DECISION DELEGATED TO HEAD OF PLANNING
DECISION DELEGATED TO HEAD OF PLANNING

Application No:	H04-0199-24	Applicant:	Cowley Academy
Proposal:	Replacement windows and internal alterations (drama block) and new fence along east elevation of drama block		
Location:	Thomas Cowley High School School Lane Donington		
Terminal Date:	17th January 2025

DRAWN BY EK	CHECKED BY EMA	DATE February 2024
SCALE 1:100 @ A1	PROJECT NUMBER 2404	
DRAWING NUMBER PP100	REV 02

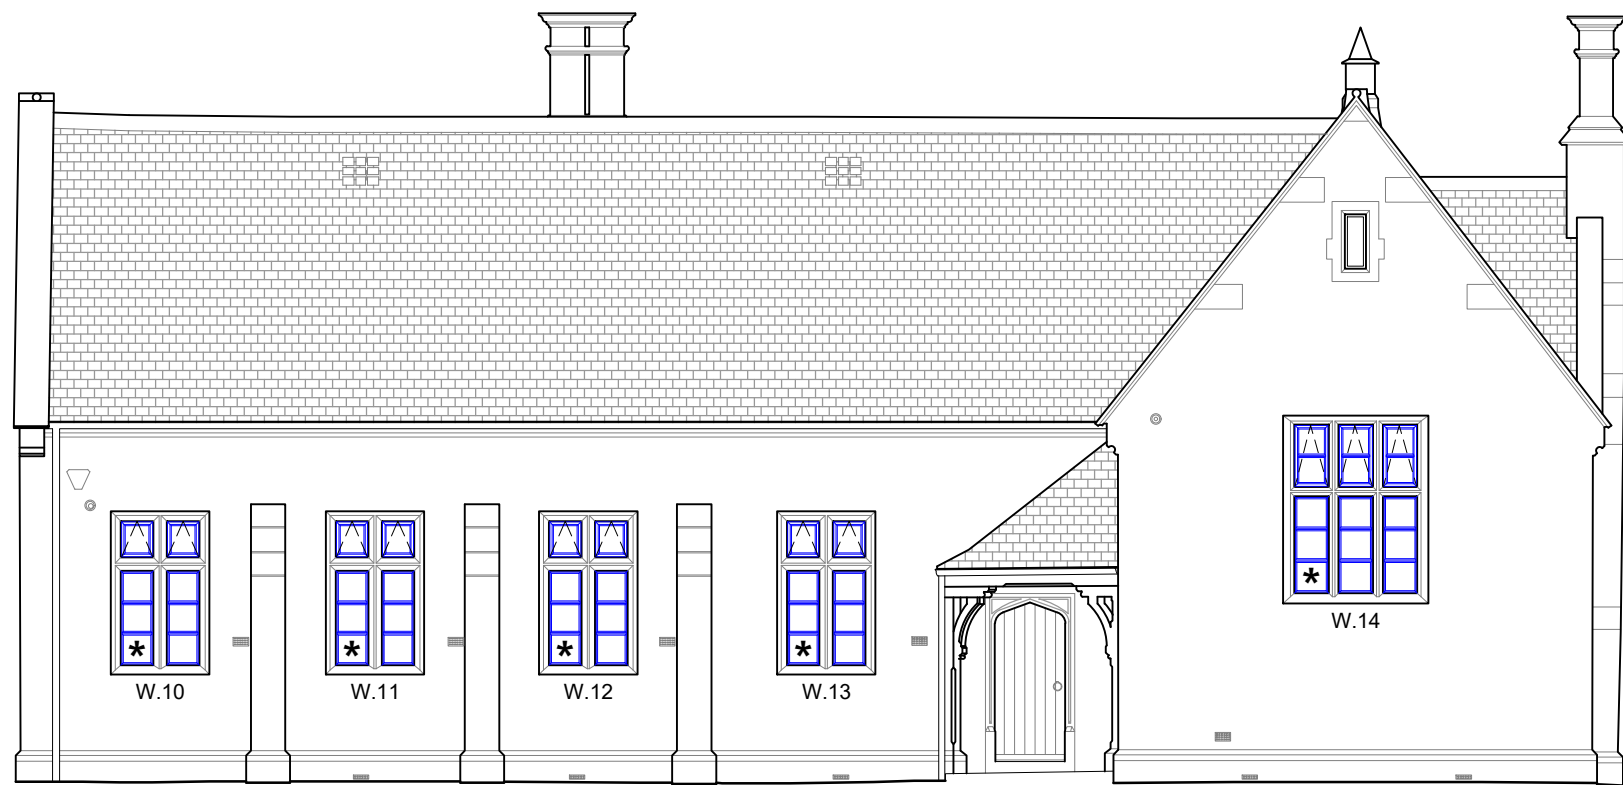
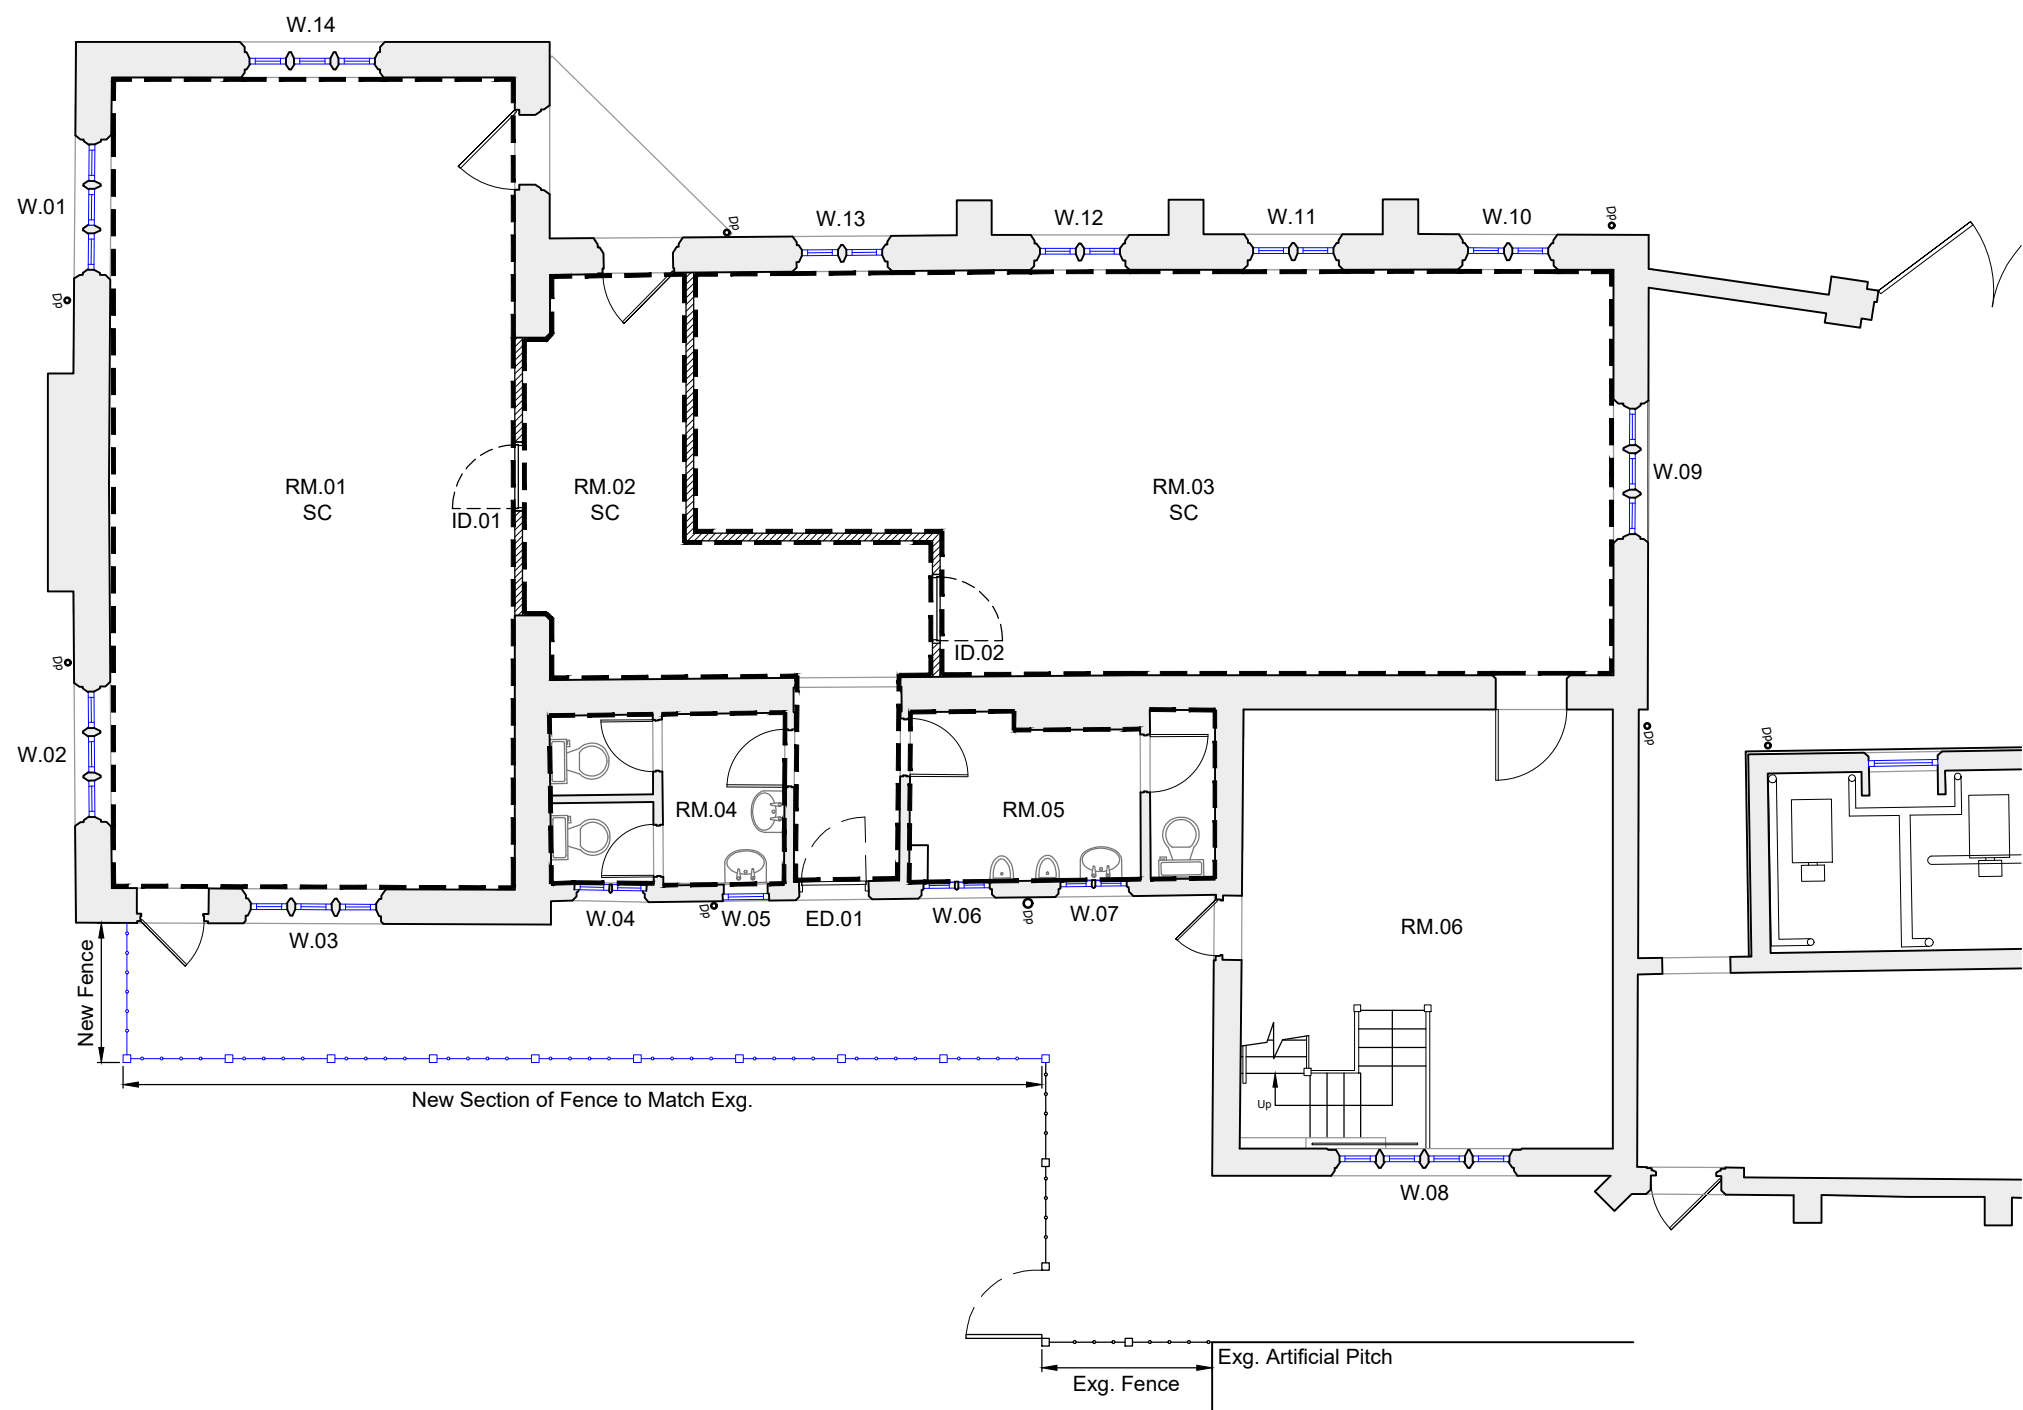
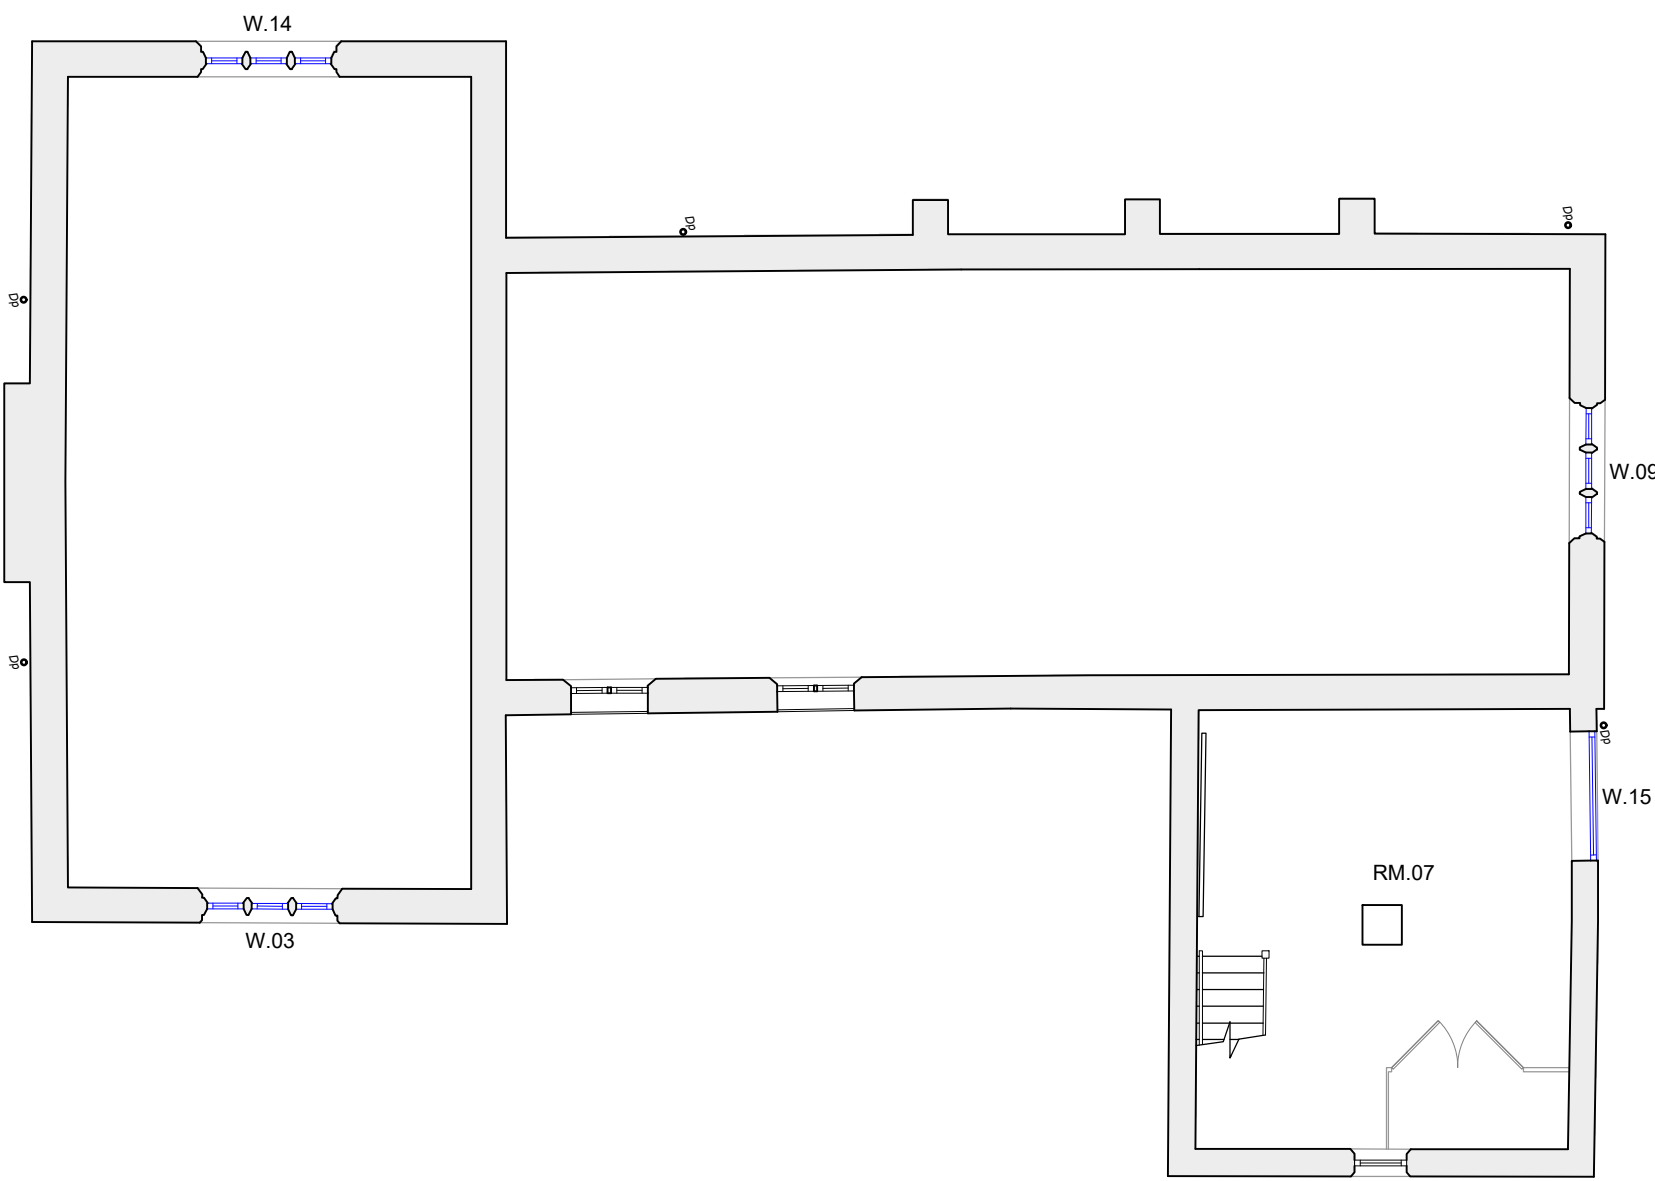
Historic England responded initially to the proposal by objecting to two aspects of the proposed development; those being that the proposed windows with overlapping openings would fail to replicate the original style and most particularly, that the proposed dry lining of the interior would strip the interior of its value.

The applicant amended the proposal to remove the proposed interior alterations.
